# Rezoning Transportation Analysis

Petition Number: 2020-072

| Revision Log: | Date     | Description  |
|---------------|----------|--------------|
|               | 07-22-20 | First Review |

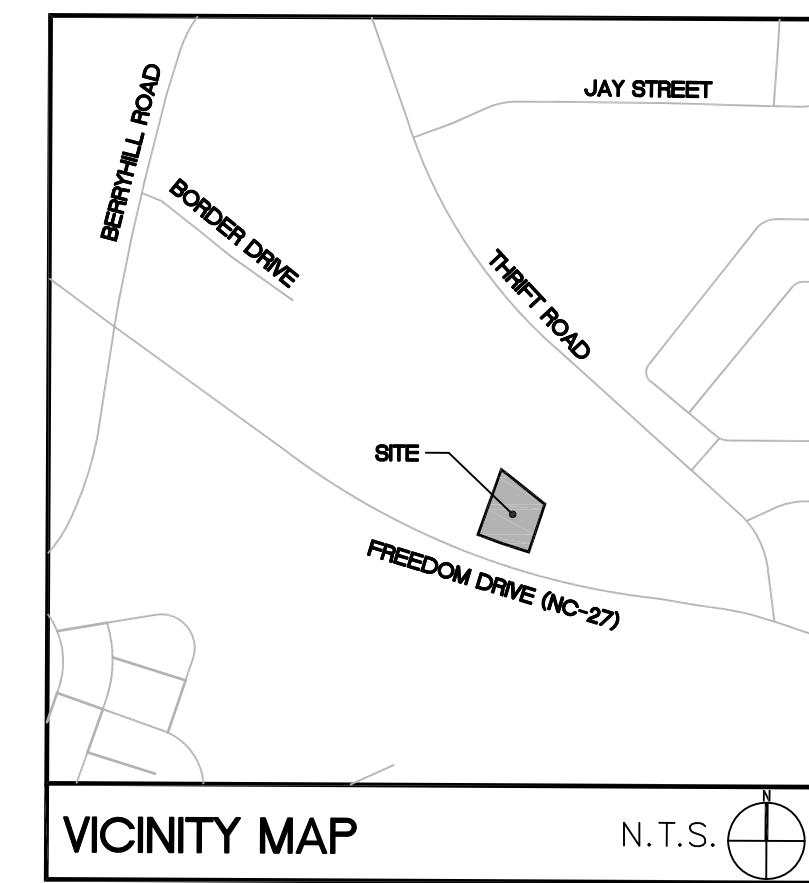
1. **Curbline** The proposed zoning district has a setback measured from back of the existing or proposed future curbline.
  - a. **Freedom Drive:** The future location of curb and gutter is 52 feet from existing road centerline.

The site plan should show the future and existing curb and gutter labeled and dimensioned from the centerline for each road.

2. **Traffic Study** A Traffic Impact Study is not necessary for the complete review of this petition due to the site generation more than 2500 daily trips. If during the permitting process the site generates more than 2500 daily trips, then a traffic study will be required.
3. The petitioner should revise the site plan and conditional note(s) to close the existing median break on Freedom Drive. NCDOT requires the proposed access to become right-in/right-out. Please show the existing travel lanes and median within the revised site plan.

4. The petitioner should revise the site plan to add a note specifying dedication and fee simple conveyance of all rights of way to the City before the site's first building certificate of occupancy is issued. CDOT requests right of way set at 2' behind back of sidewalk where feasible.
5. The petitioner should revise the site plan to add a note specifying all transportation improvements will be approved and constructed before the site's first building certificate of occupancy is issued. The petitioner may phase transportation improvements if said improvements and phasing are explicitly described in site plan notes.
6. **Resolved** ~~Sample format for comment that is resolved~~
